# City of Albuquerque Stormwater Construction Site Inspection Report

Project Name and Location	McMahon Market place Unsu and McMahon		
Site Contact Name & Agency	Tom Newell ASC Guard Contractor	Contact Phone #/ E-mail	401-4639
Date of Inspection	1-31-17	Start/End Time	12:30 / 12:55
Inspector Name, COA Dept.	Curtis Cherne, Stormwater Quality		
Inspector Phone / E-mail	505-924-3420/ccherne@cabq.gov		
Inspector Qualifications	Qualified Compliance Inspector of Stormwater- Stormwater One		
Describe Present Phase of Construction	Stabilized		
Type of Inspection:	<input checked="" type="radio"/> Regular <input type="radio"/> During storm event <input type="radio"/> Post-storm event (> 0.5 inch) <input type="radio"/> 311 / Complaint Response <input type="radio"/> Follow-Up

**From:** Cherne, Curtis  
**Sent:** Wednesday, September 14, 2016 9:53 AM  
**To:** 'grant@inspectionsplusinc.com'  
**Subject:** McMahon Marketplace SWPPP Inspection  
**Attachments:** no\_track-out\_pad.jpg; stockpile\_egress.jpg; trash.jpg; west\_edge.jpg

### McMahon Market Place

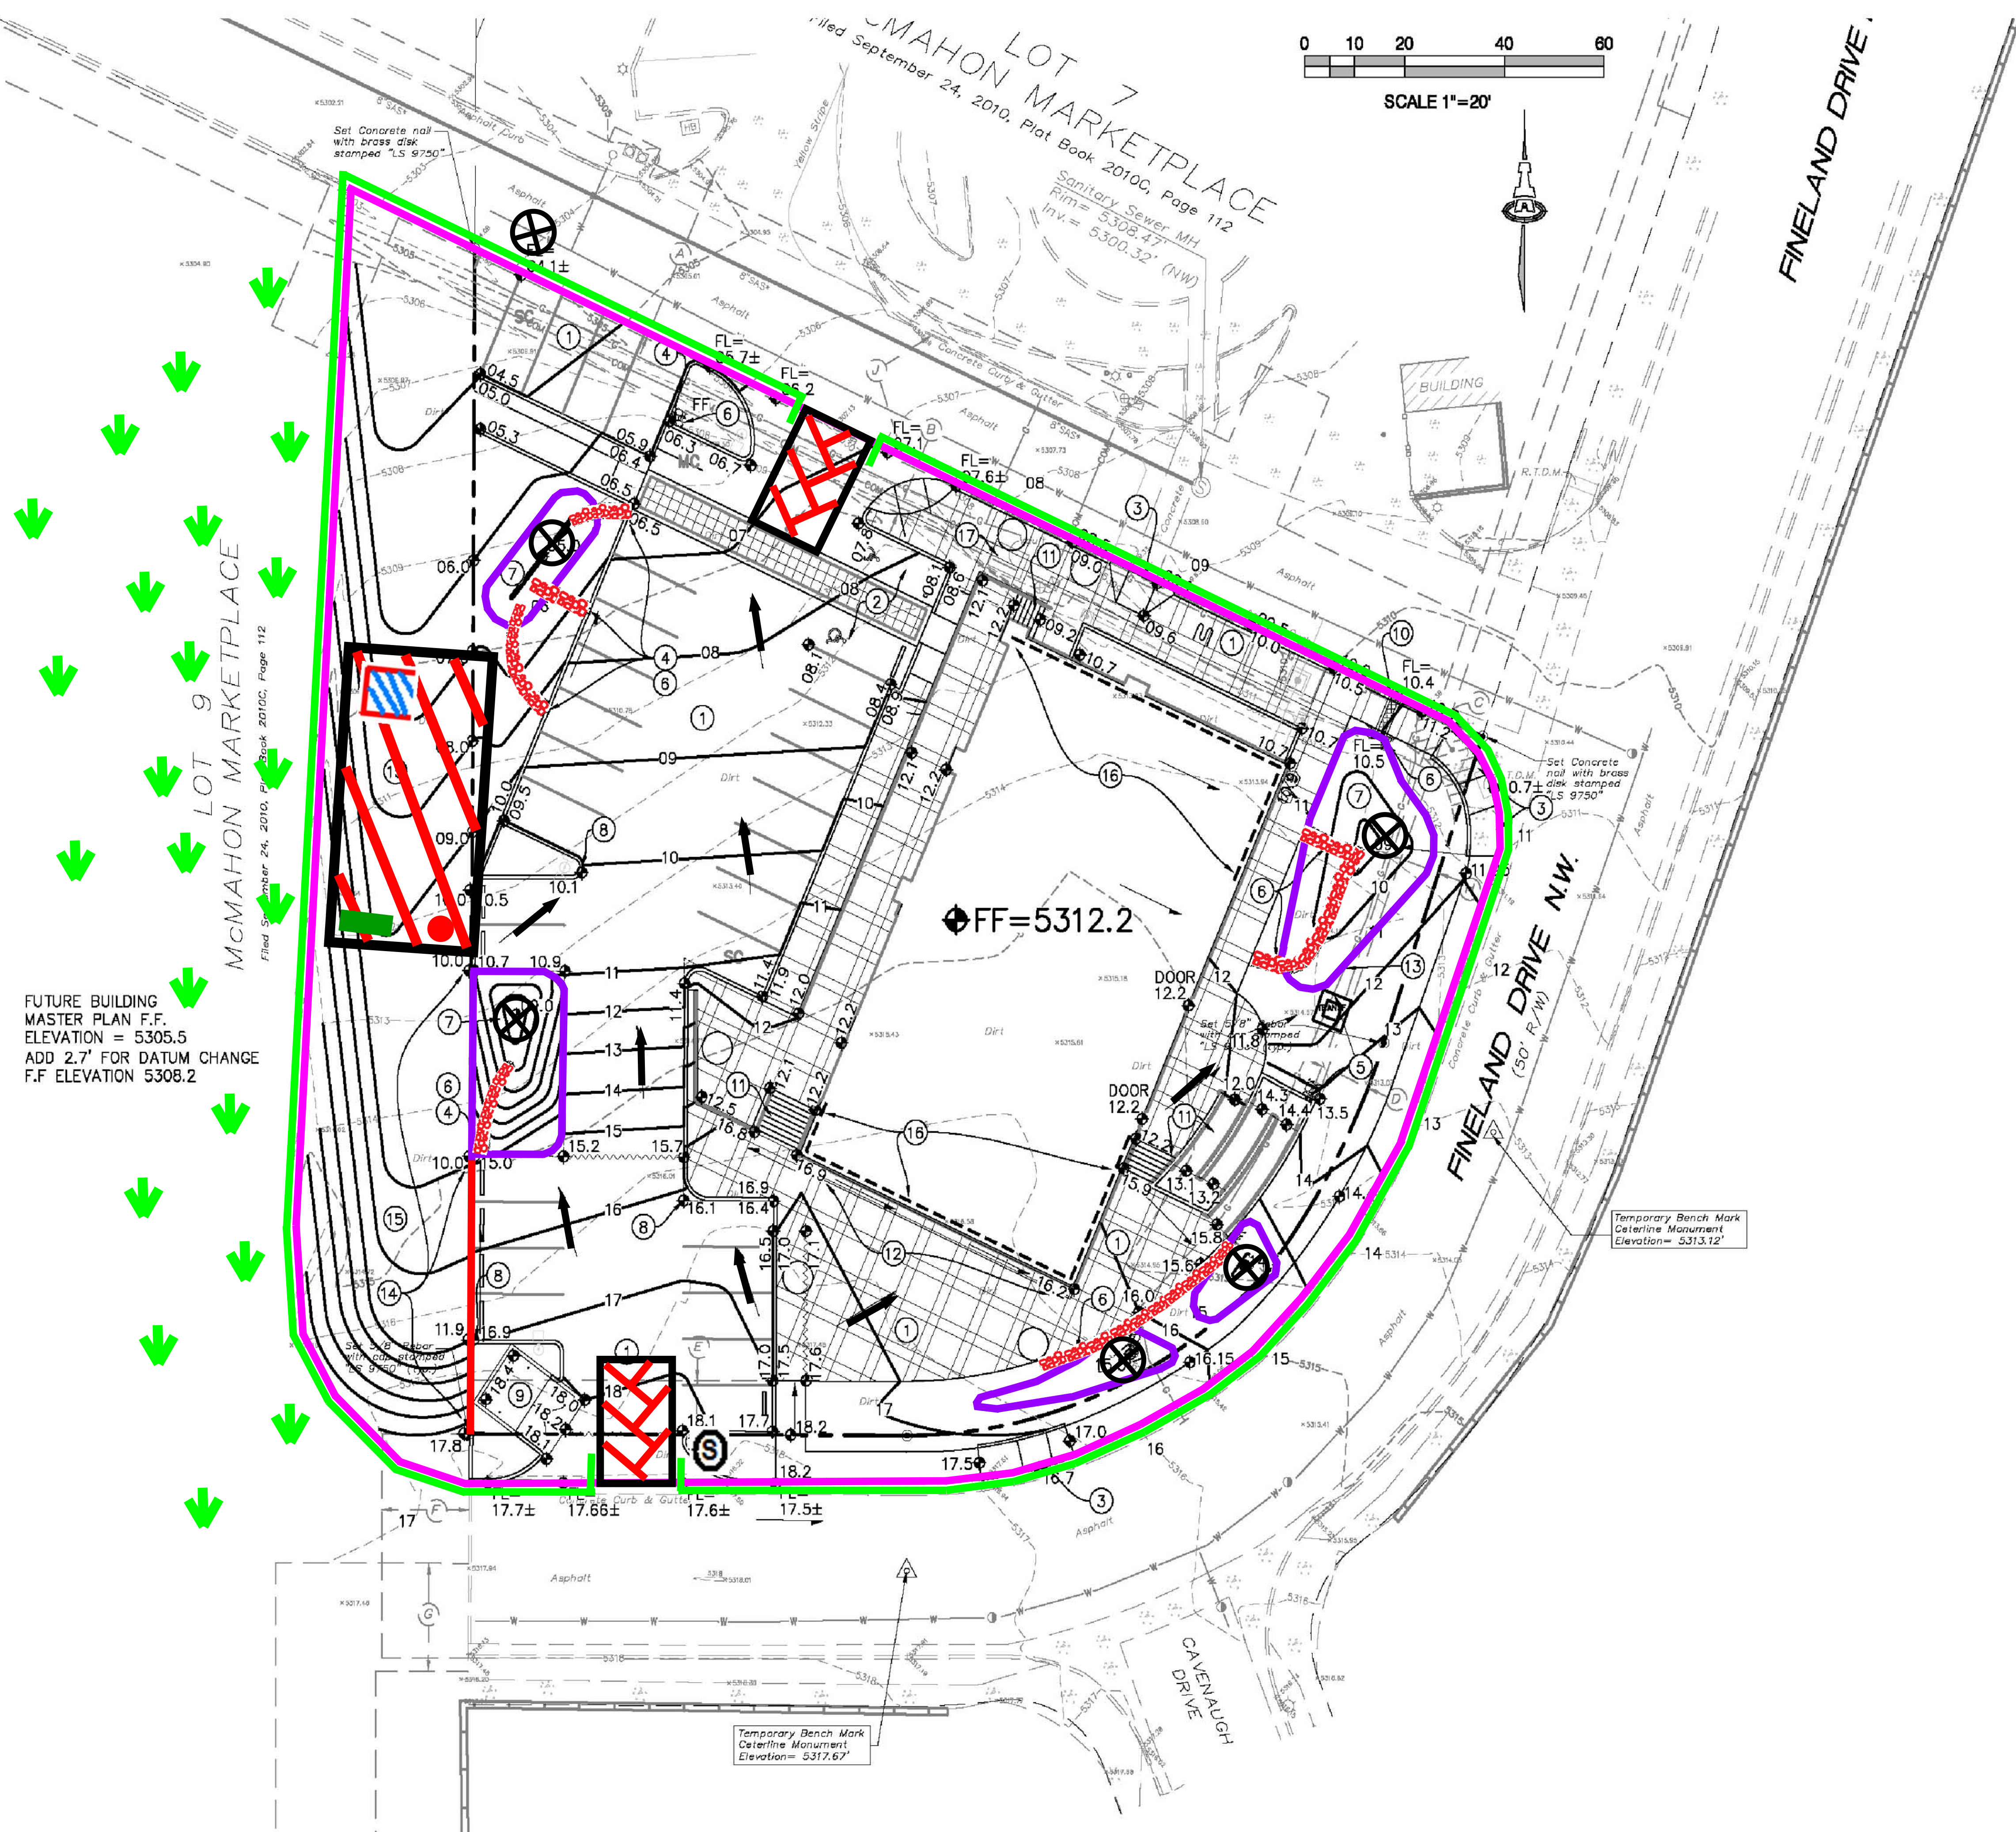
- Entrance / Track-Out no entrance - has 2 sides with road 2
- Sediment Controls / Silt Fence, Check Dams, Waddles, etc. 1500 yds stockpile on site west of McD's  
old sediment berm on west side
- Erosion Controls / Mulch, Seed, old berm along road on the north side  
no sediment berm west side of site - leave berm?
- Housekeeping/Pollutant Controls trash
- Debris/Pollutants/Sediment in MS4 NO
- Notes \_\_\_\_\_

1. No track out pad at exit to site being graded. I spoke with Tom and we agreed that he would put in two track-out pads: one at the entrance to the site being graded and another at the stockpile lot.
2. In addition, folks are driving out to McMahon next to the stockpile lot and are tracking-out sediment. Not sure if we can block this off. He said he will look into it.
3. A bit too much trash. He needs to keep a clean site.
4. There is no sediment BMP on the west edge. I think it is OK, if the berm/pile over there directs water to the north. A little bit of sediment that may run off the dirt pile will be filtered by the veg.
5. I didn't take a picture but we discussed a berm/silt fence at the north edge running a distance west from the exiting silt fence on the northern edge. Currently, flows from the site will drain west of the current silt fence installation

I just went by and we're getting on this. We installed some silt fence about a week ago but it was such chaos they couldn't decide where they would enter, etc.

Anyway it will look good next time you go out. We're having to amend the SWPPP since they put the construction trailer and entrance to the west.
